Application No: AB/59/20/PL
Site Address: 65 Tarrant Street Arundel BN18 9DJ
Description of works: Change of use of loft space from office storage to office work space & 2 No dormer windows to roof. This application affects the character & appearance of the Arundel Conservation Area. This application is not CIL Liable as in CIL Zone 2, (zero rated) as 'other development'.

Thank you for your internet representation made on 7th July 2020 which has been recorded as no objection with the comments as follows:

Tarrant Street Elevation as Proposed

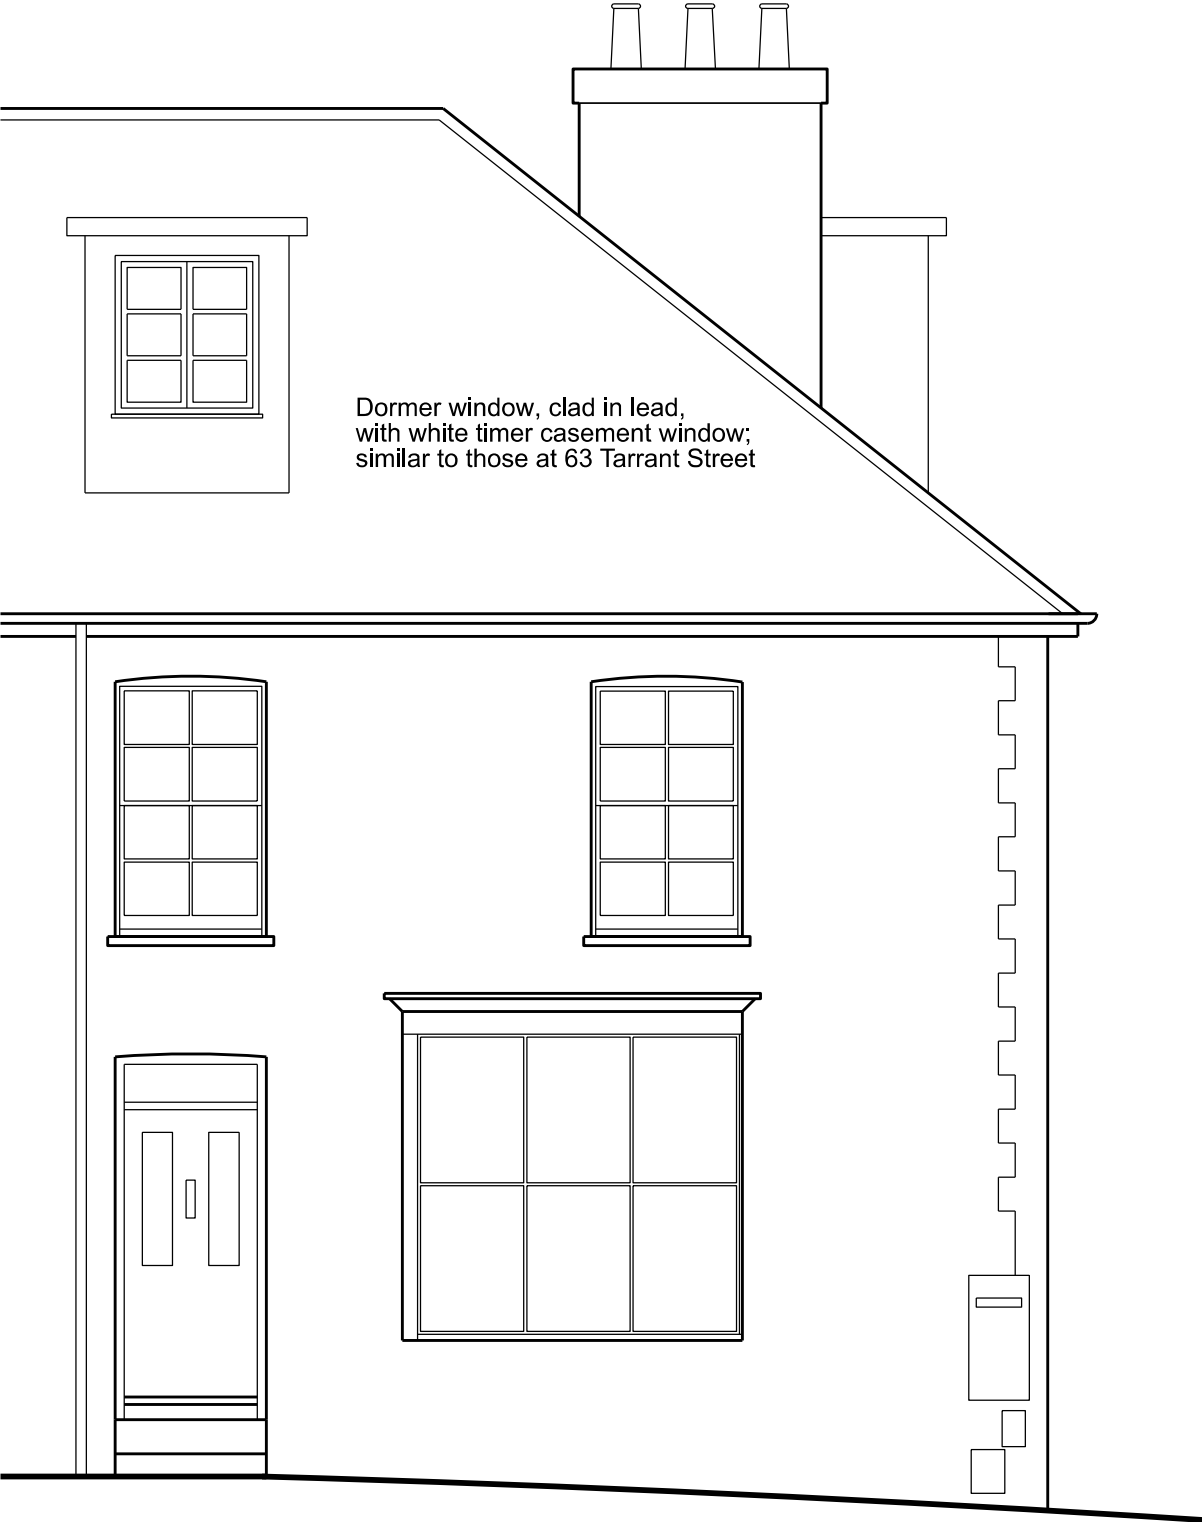
From the point of view of the external appearance of the property, I applaud the application for seeking to match the design of the proposed dormer windows to those in adjacent and nearby buildings. It occurs to me that the design could be improved further by maximising visual consistency among the windows of the property. Whereas the existing windows vary in appearance they share the common feature of having glass area divided vertically into halves and quarters. The proposed dormer windows divide the glass area into thirds. I would suggest that by dividing these glass areas into halves, the dormer windows will fit better visually with the other windows of the property.
